# Laneside Barn, Grindleton – Addendum to the Structural Inspection for Planning

**Description:** For client and planning approval

**Project:** Laneside Barn  
**Client:** Mr. Keith Lee  
**Description:** Addendum to: Structural Inspection  
**Date:** 4<sup>th</sup> December 2024

Figure 2: Site layout and nomenclature of the main barn and additional structures.

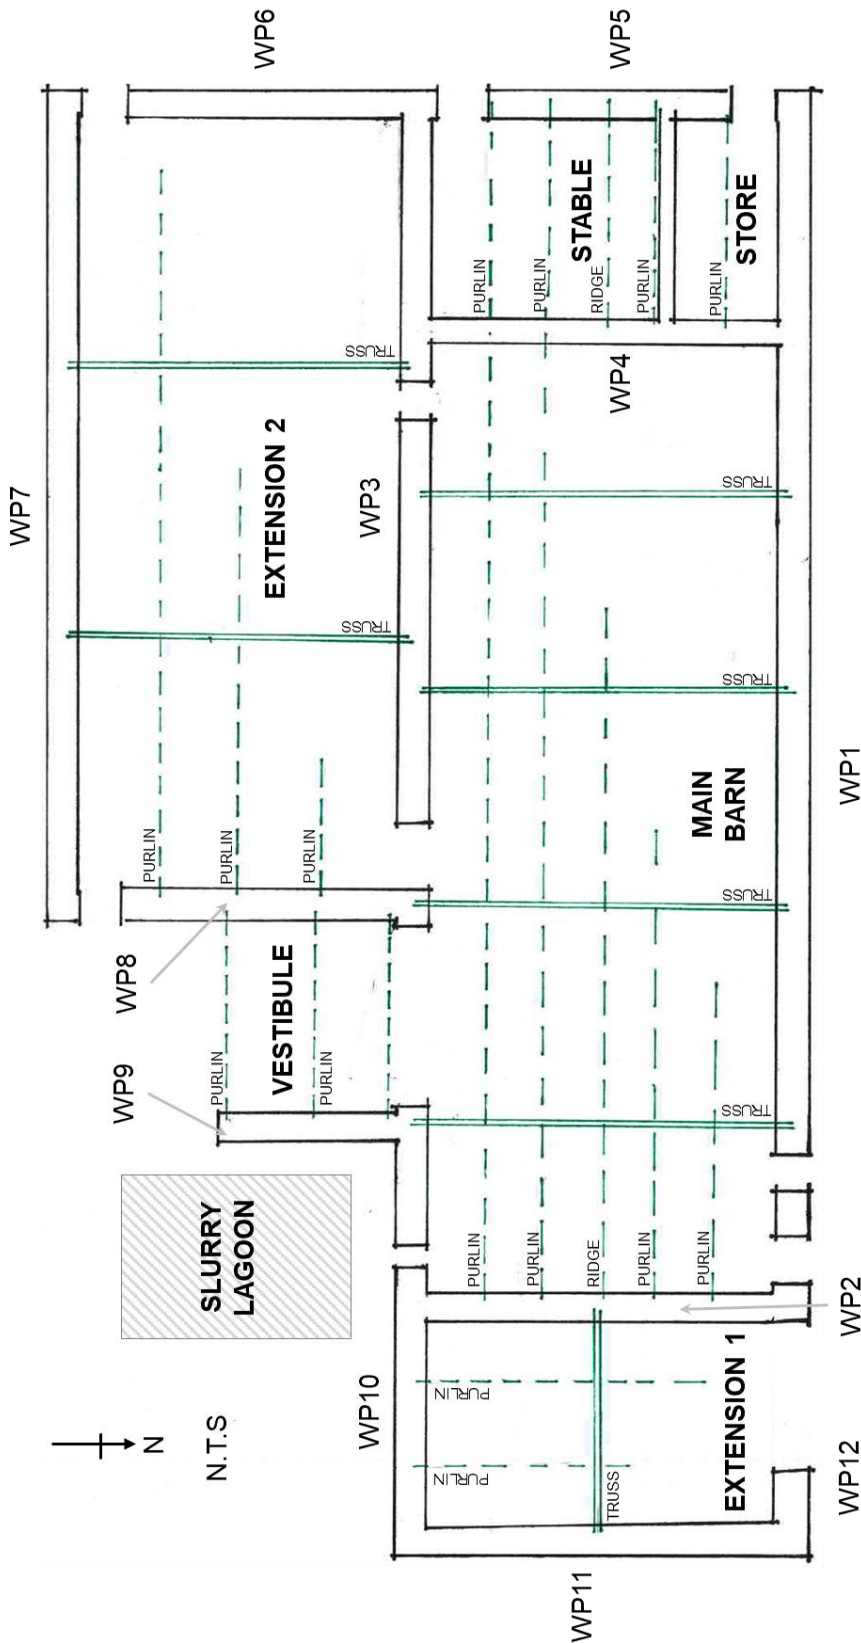
WP 7 has suffered from a shallow foundation which has been wet for a long period of time due to the lack of guttering to the large roof area directly above. The water discharging onto the ground here will have softened the soils, allowing the wall to settle at its outer edge by a small amount. The settlement of the outer portion of the wall relative to the inner portion sets up a rotational type of movement which has manifest in an outward lean which was most pronounced at its eastern end.

During the inspection, a maximal outward excursion of 75mm was estimated with a plumb bob and measuring tape. By conservative engineering theory for materials such as masonry, a freestanding (unrestrained) solid wall may deviate up to one sixth of its thickness before it is considered unstable – a manifestation of the ‘middle third rule’ for compressive structural elements. A cavity or other construction such as a rubble fill type wall (such as WP7) would reduce this limit slightly, and WP7 exceeds this limit.

If a wall is restrained against further movement (i.e. no longer considered to be freestanding), an often-quoted rule of thumb for structures of this nature is that 50 – 85% of the walls thickness is an acceptable and stable bulge, if the wall can be restrained<sup>1</sup>. Suitable restraint can be arranged by means of a firm connection to the roof structure and where necessary by some posts framing the proposed opening and concealed in the new construction to tie back to at the opening.

With the existing wall stabilised, the issue of the shallow foundation and the (likely) softened soils upon which they bear must be addressed. For this we recommend some localised underpinning at the eastern end of the wall, and some investigations into the ground conditions at the western end with a view to some additional underpinning locally if required.

Underpinning has successfully been undertaken to similar heavy masonry structures for decades. The underpinning would be carried out in the classical manner, excavating small bays by hand in a specified sequence, sized to suit the masonry characteristics and flooding with concrete to underpin. This underpinning would be undertaken prior to the formation of the proposed opening and would also require the careful propping / shoring of the eastern free end during excavations for the end bay.

- Localised underpinning of WP7 at its eastern end, with investigation by excavation at the western end and underpinning if required here also.
- Any small areas of damaged or excessively deformed masonry should be rebuilt during works.
